## Application for a Non-Material Amendment Following a Grant of Planning Permission

UB7 8DN

First floor side/rear extension

45648/APP/2021/870 & 869

Stage: Planning	Job Title: First floor side/rear extension	Job Number: 58RL	Drawing Number: 02
	Client: Alexandre Vorobiev	Scale: 1:100 @ A3	Revision Suffix:
Drawing Title: Proposed Elevations	Site Address: 58 Royal Lane, West Drayton, UB7 8DN	Date: 05/07/2022	Drawn By: AA Checked By: -

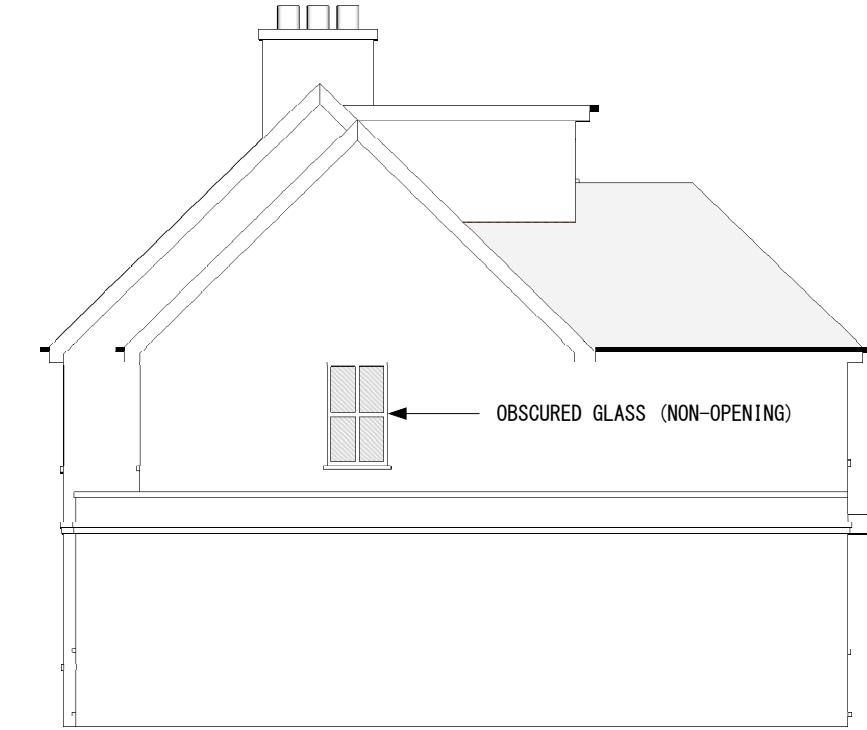
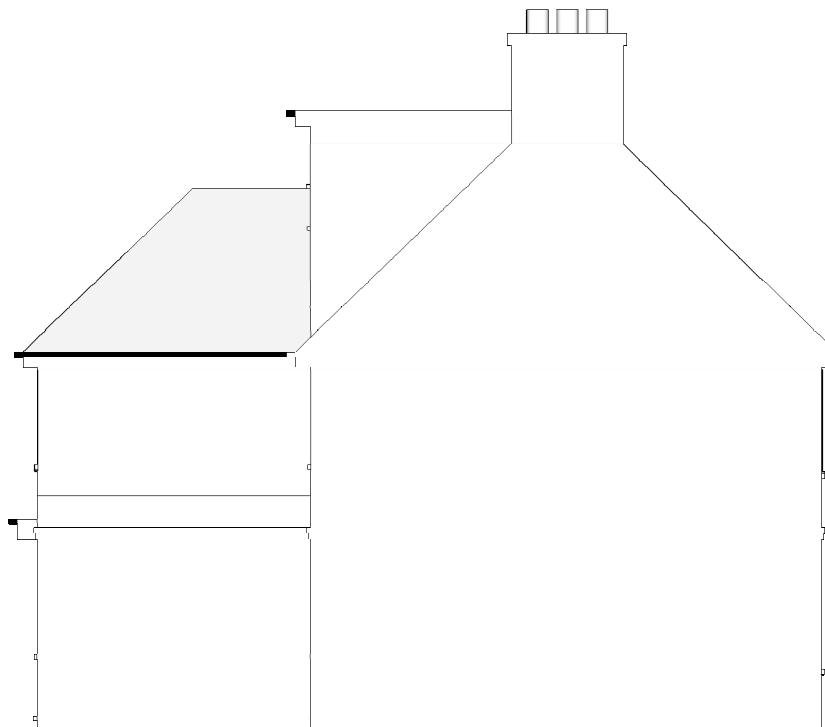
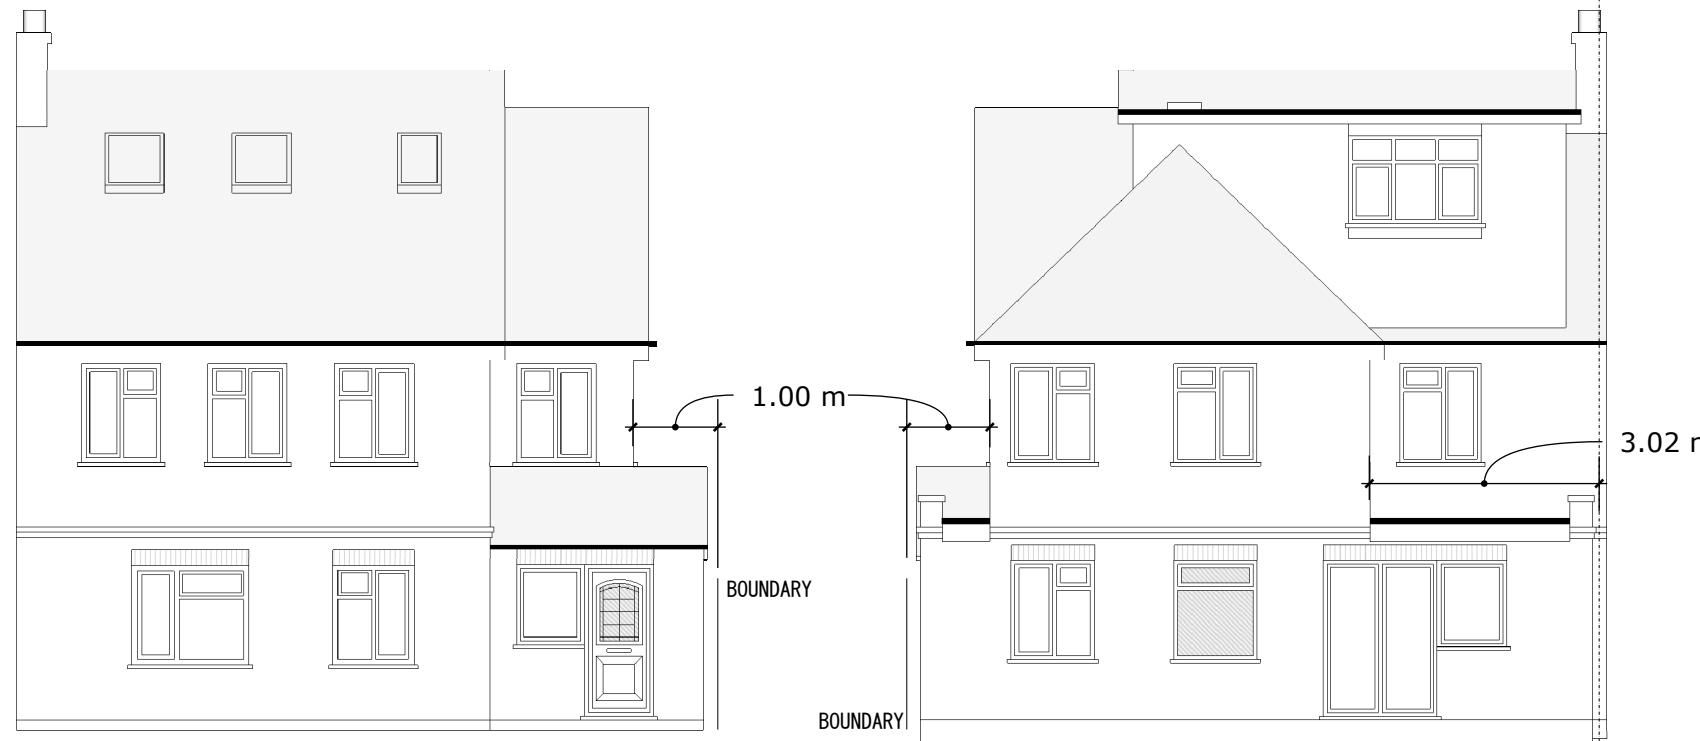
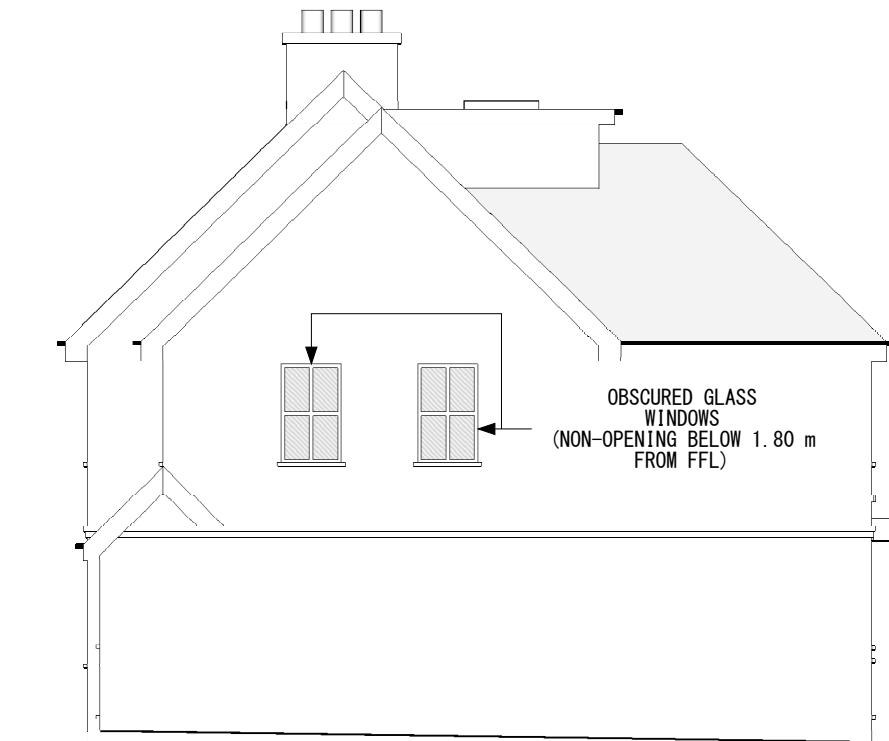
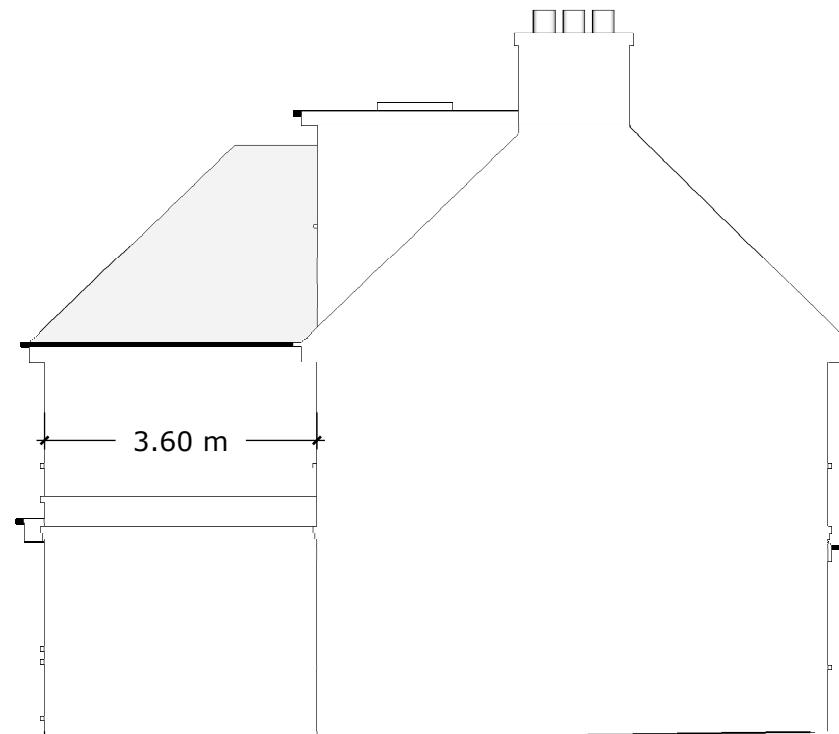
1. Amend dimensions of all existing windows, skylights, & doors, and their respective positions, as on site.
2. Amend all eaves overhang to match existing dwelling.

3. Amend internal plan layout, as on site.
4. Add another obscured glass window on the side elevation & reposition previously approved window.
5. Slightly increase the width of side extension but still retain the required 1 metre separating distance from the side boundary (as per other approved scheme under planning reference 45648/APP/2021/869).

6. Increase window size on the proposed second storey side extension at the front and directly at the rear.
7. Create small pitched roof over existing ground floor extension at the front (as per other approved scheme under planning reference 45648/APP/2021/869).

8. Removal of small window on roof dormer rear elevation which is situated on loft floor level staircase landing, and replace with skylight window on the flat roof of the rear roof dormer.

1. Accurately reflect how the completed development will look on site.
2. Mimic original dwelling features to create harmonised roof design.
3. Accurately reflect how the completed development will look on site.

4. Provide more daylight to the dark corner, also approved position clashed with redesigned staircase and partitioning wall.
5. As per structural engineer recommendations, not to support new masonry walls directly in the middle of structural openings below, dimensions also match other approved scheme under planning reference 45648/APP/2021/869.

6. Provide more daylight and create more harmonised look matching existing window design and their size/positions.
7. Mimic original roof slope and break the large parapet walls at the front, also matches other approved scheme under planning reference 45648/APP/2021/869.

8. Hipped roof of the second storey rear extension now completely blocks the existing staircase landing window, to provide daylight a skylight window to be introduced, which will also provide servicemen access to the rear dormer flat roof and chimney stack.
